Date: 02 May 2018  
Your Ref: EN010082  
Our Ref: 8.1

**EN010082 – THE TEES COMBINED CYCLE POWER PLANT PROJECT – PROPOSED NON-MATERIAL CHANGE IN RELATION TO BUILDING HEIGHTS**

At the Issue Specific Hearing on 10 April 2018 the Applicant introduced a proposed change to increase the potential maximum height of the turbine hall and heat recovery steam generator ('HRSG') buildings beyond what is currently set out in the draft DCO (Examination Ref: APP-005). The Examiner ('ExA') subsequently requested that further information be provided in respect of the proposed building height increases and the implications for the Proposed Development in order to consider whether to accept the change.

Title APPLICATION DOCUMENT REFERENCE No. 4.5  
 INDICATIVE GENERATING STATION PLAN SHEET 3 of 3  
 SCALE 1:2500

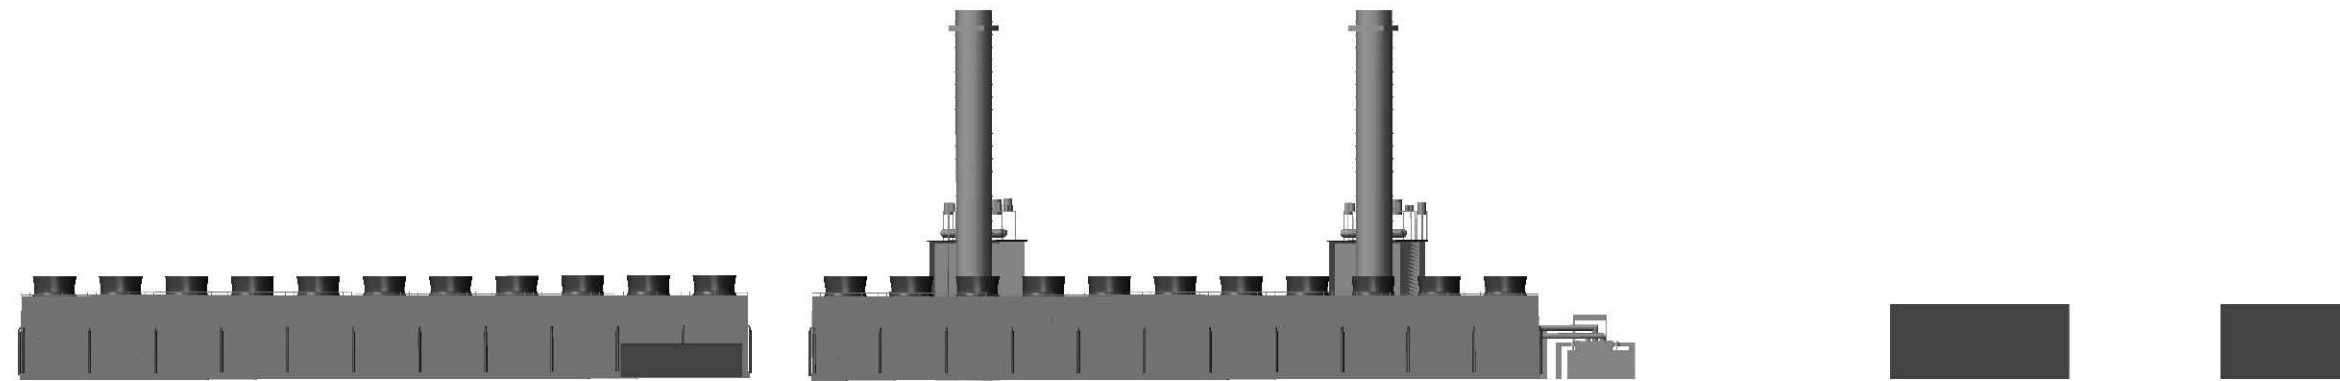
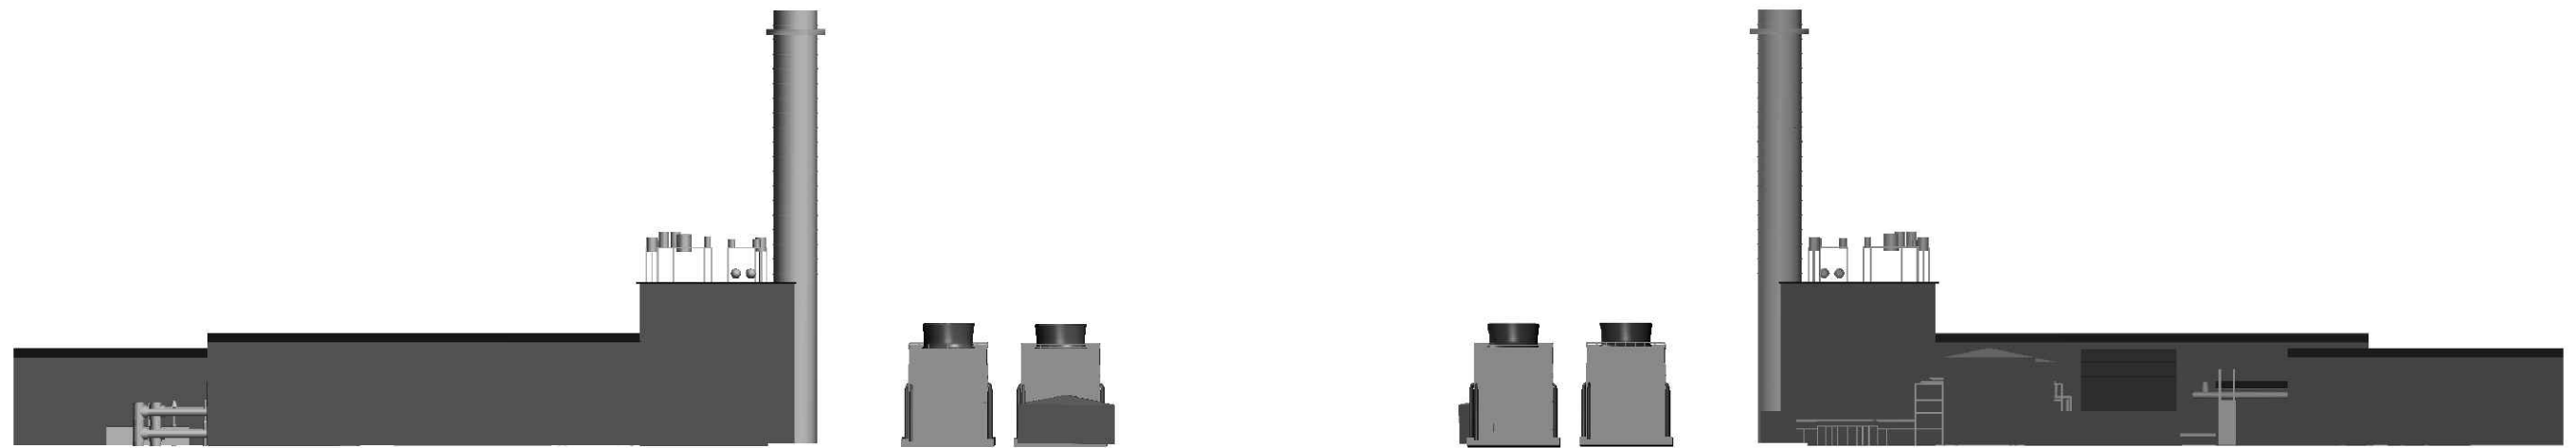
- an increase in the maximum height of the turbine hall buildings from 25 metres ('m') to 32 m; and
- an increase in the maximum height of the HRSG buildings from 44 m to 45 m.

The above comprise Work No.1A (a) and Work No. 1A (b) of the draft DCO (Examination Ref: APP-005). The current maximum heights (25 m and 44 m respectively) are set out in Schedule 2, Requirement 4 of the draft DCO.

- Application Guide (Application Document Ref: 1.2) – Rev 3;
- Draft Development Consent Order (Application Document Ref: 2.1) – Rev 2;
- Indicative Generating Station Plan Sheet 1 (Application Document Ref: 4.5) – Rev 2;
- Indicative Generating Station Plan Sheet 3 (Application Document Ref: 4.5) – Rev 3;
- Design and Access Statement (Application Document Ref: 5.6) – Rev 3;
- Environmental Statement, Volume 1 – Chapter 5 Project Description and Alternatives (Application Document Ref: 6.2.5) – Rev 2;
- Environmental Statement, Volume 1 – Chapter 7 Air Quality (Application Document Ref: 6.2.7) – Rev 2;

Updated Photomontage - after requested change

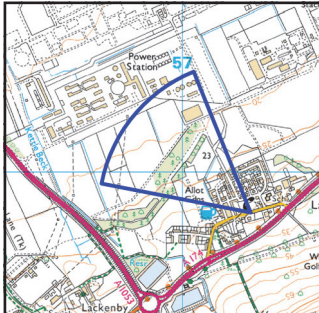
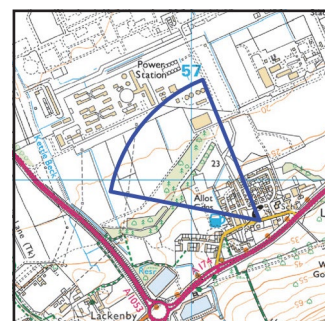
- Environmental Statement, Volume 1 – Chapter 11 Landscape and Visual Amenity (Application Document Ref: 6.2.11) – Rev 3; and
- Environmental Statement, Volume 2 – Annex K Photomontages (Application Document Ref: 6.3.19).

In reviewing these topics, the information concludes that there are no changes to the conclusions presented in the ES submitted as part of the Application and the building height change is not material to the overall findings of the EIA.
